02 June 2020
Ref: RH/Let/P1483i

Discharge of Conditions 14, 15, 16 and 18 pursuant to Application Reference A/74/18/OUT (Outline Planning Permission with all matters reserved, except access, for the demolition of existing outbuildings and the erection of 9No. two storey dwellings consisting of 2No. two bedroom dwellings, 3No. three bedroom dwellings and 4No. four bedroom dwellings) at The Laurels, Dappers Lane, Angmering, BN16 4EN.

Appendix A – Answers to Arun’s Drainage Engineer’s Queries in email dated 24 April 2020 (in red)

CLIENT	Oceanview Developments		
PROJECT	The Laurels Dappers Lane Angmering		
TITLE	Proposed Ownership Plan		
DRAWN	M Pacifico	DATE	Oct 2019
ENGINEER	M Kempshall	CHECKED	SRM
SCALE	1:500 @ A3		
PROJECT NO.	23260		
DRG. NO.	102	REV.	C

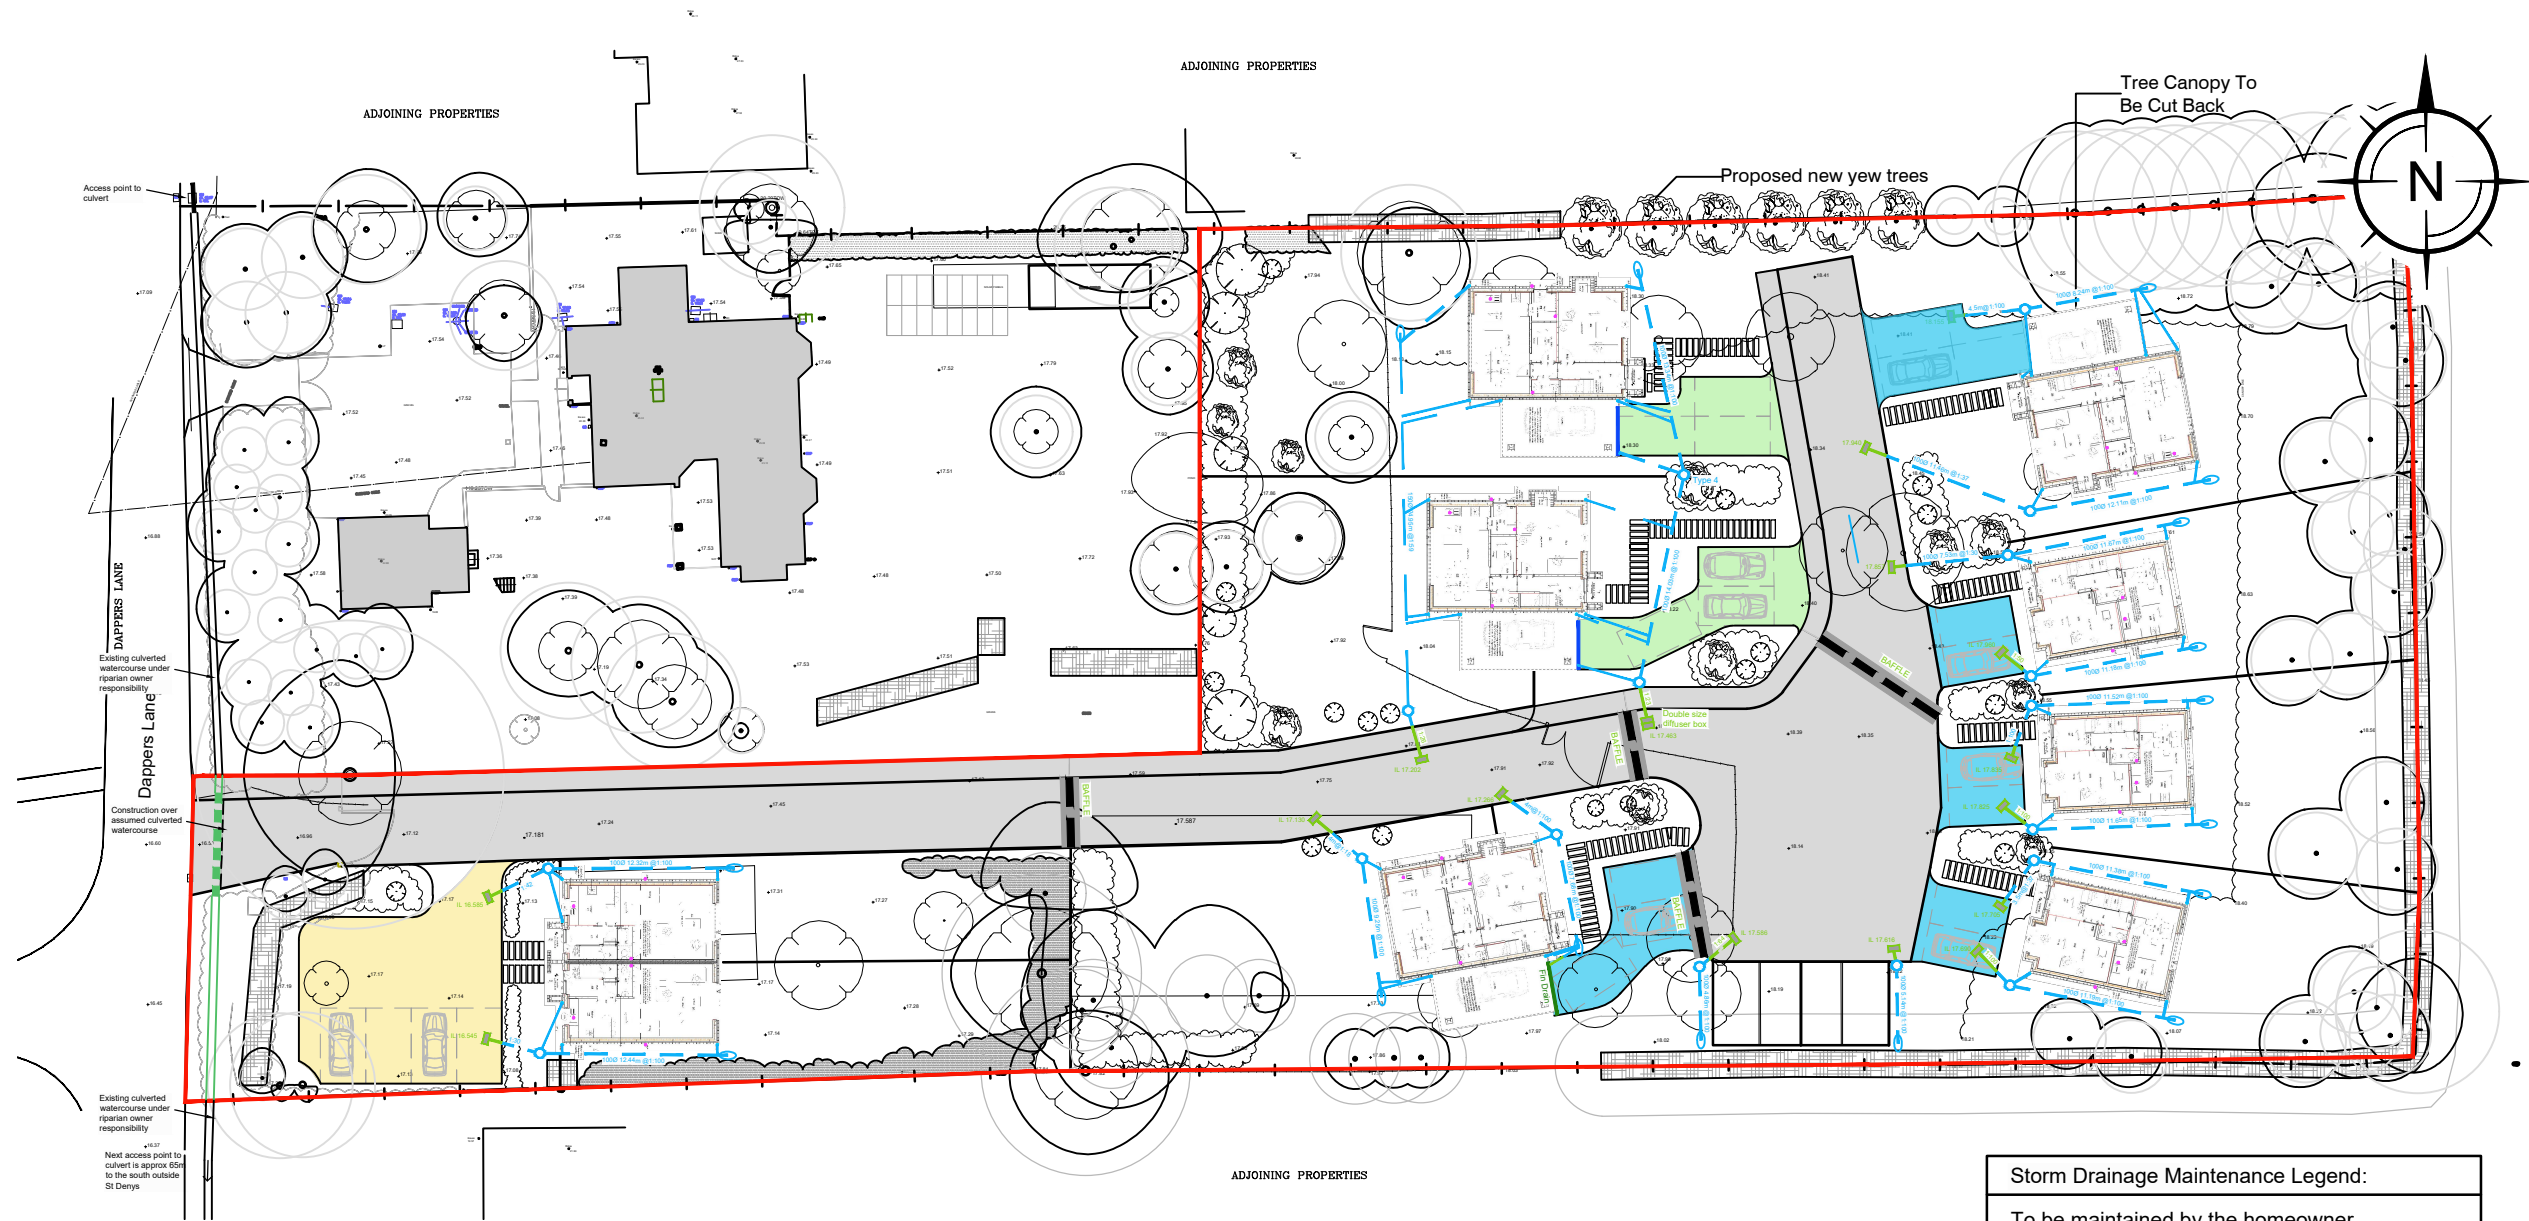
6. *Include the ‘no dig’ area on drg. 103B.*

- a) *Remove references to components that are not relevant ie. channel drains, infiltration basin, oil interceptor, etc.*
- b) *Items 1.1.3 and 2.1.1 – to include driveways?*
- c) *Approved drawings will need to be attached once available.*
- d) *Include entire length of culvert on drg. 102B where within red line (as per key) but also include culvert outside of responsibility including the manhole location (for access).*
- e) *Drawing 102B needs a specific table for the culvert maintenance/inspection, also referencing the point of access for CCTV, etc.*

This has now been added to all drawings.

Maintenance Manual has been updated and all above details have been added, or removed as required.

CLIENT	Oceanview Developments		
PROJECT	The Laurels Dappers Lane Angmering		
TITLE	Construction Details		
DRAWN	M Pacifico	DATE	Nov 2019
ENGINEER	M Kempshall	CHECKED	SRM
SCALE	As Shown @ A1		
PROJECT NO.	23260		
DWG. NO.	501		
REV.	A

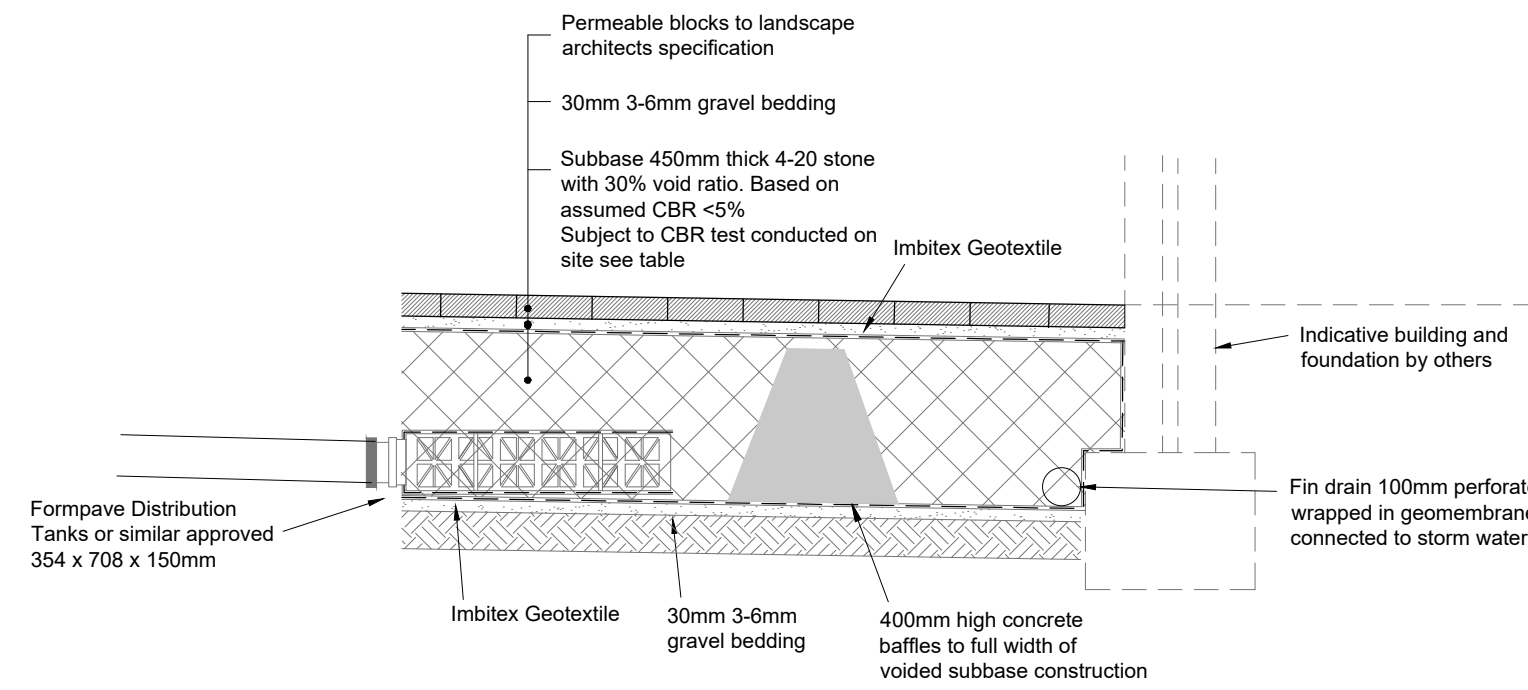
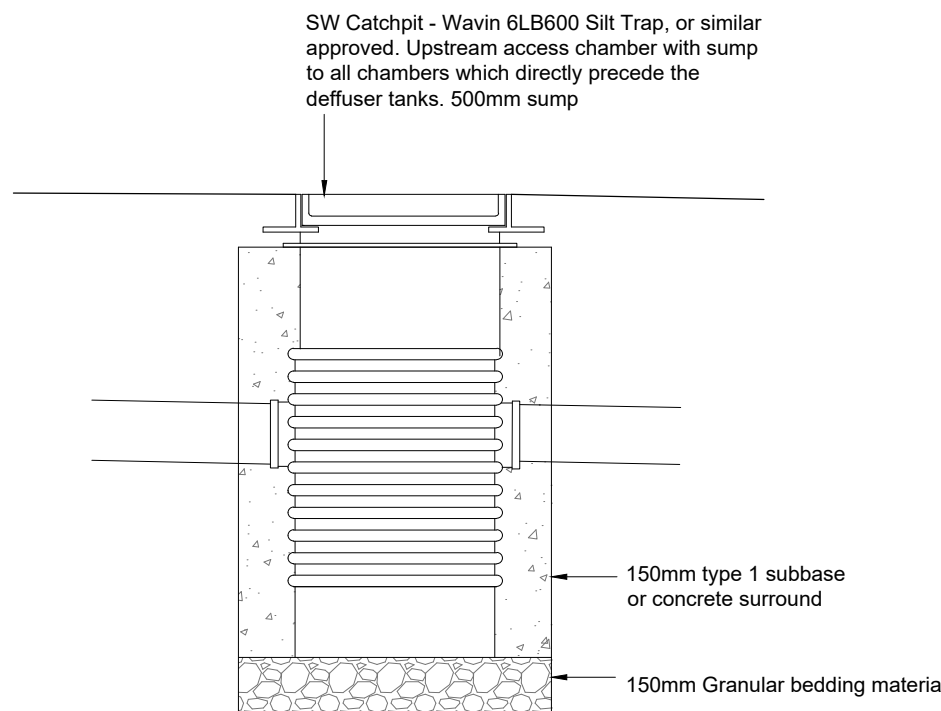
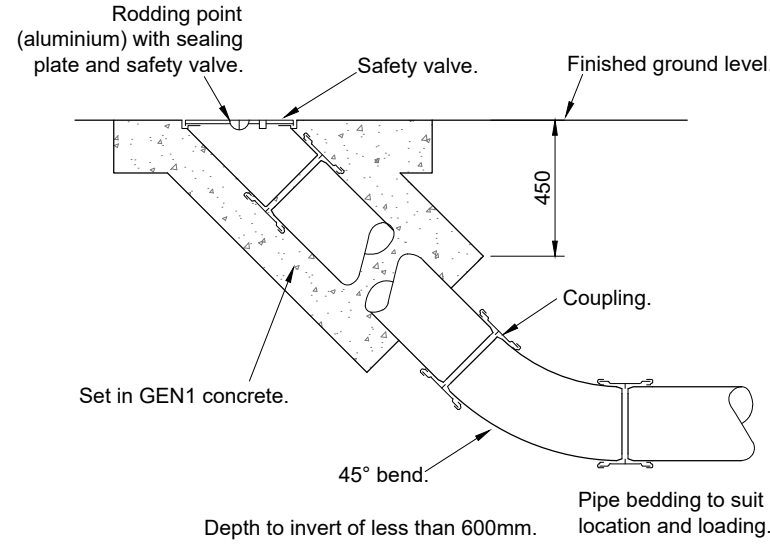
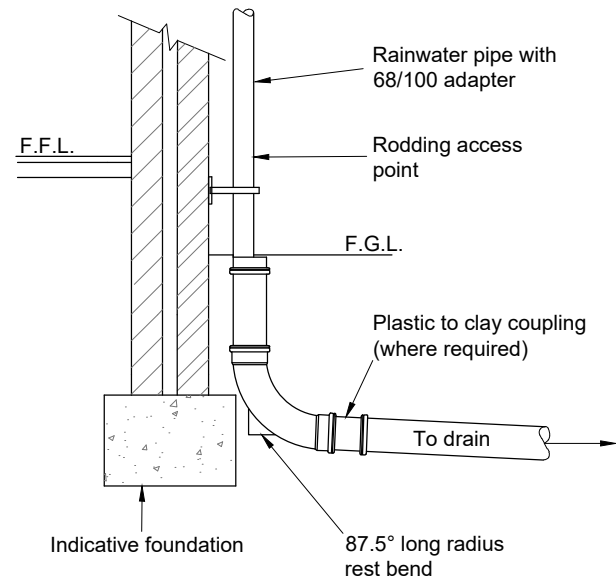
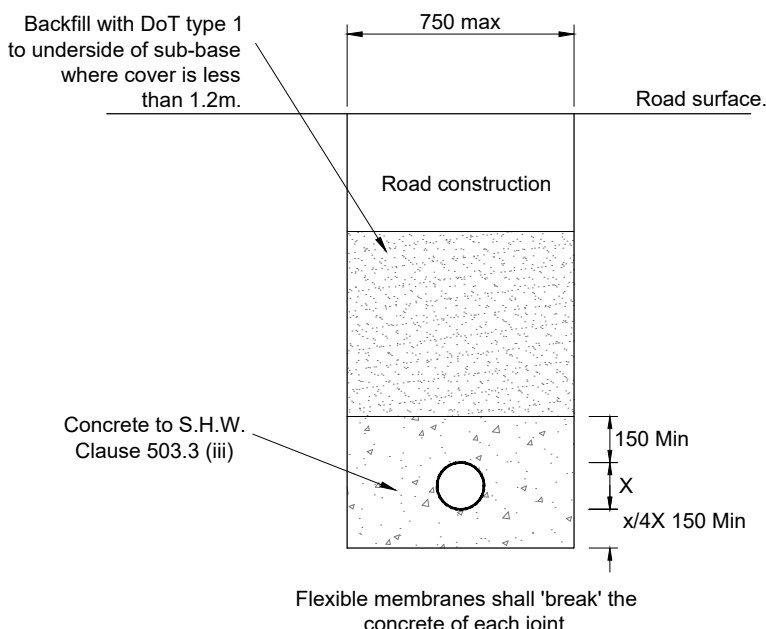
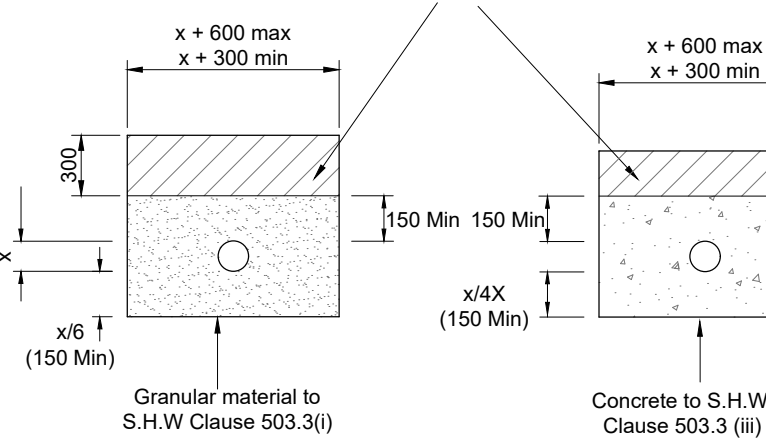
8. *Provide baffle construction details.*

9. *Silt traps are required immediately upstream of all connections to the permeable pavement. Alter plan and provide construction detail (300mm sumps).*

14. Pipe bedding – specify class S and Class Z only.

15. Permeable paving construction detail – show permeable membrane fully wrapped around the sub base and also around the distribution crate.

Baffle construction detail is now provided on Drawing 501.

This has been updated and reflected on drainage Drawing 201 with detail added to drawing 501.

This is a design preference and is only a requirement where drainage is to be adopted. We have now included class S and Z pipe bedding on the construction details.

This is a design preference. We have added this in light of a change to the subbase design of the permeable paving. Distribution crates typically do not require to be wrapped, the outer layer is typically a 2mm mesh fabric as per the permavoid diffuser units.
